Application no: H17-0725-09

Description: Proposed bus shelter

Amendment: Position of shelter clarified (dwg. no. TD/SPC/09/SK1)

ACKNOWLEDGEMENT OF AMENDMENT

Plan

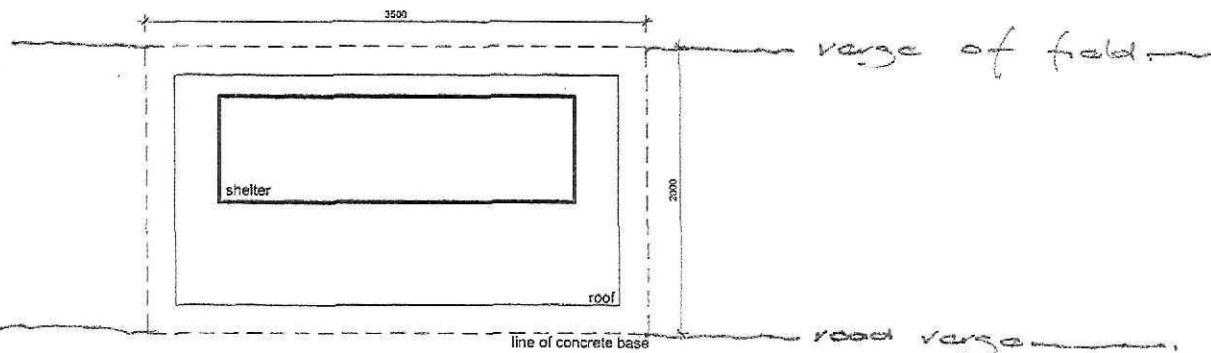
With reference to the recent objections regarding the above development infringing from the Highways grass verge onto the adjacent owners land I have rechecked the depth of the verge at the site and found it to be 2.00m wide, which will accommodate the shelter and base.

I have therefore altered the plans accordantly to show the shelter actually adjacent to the road and the position of the rear of the verge adjacent to the field, which I hope is sufficient to clarify the matter.
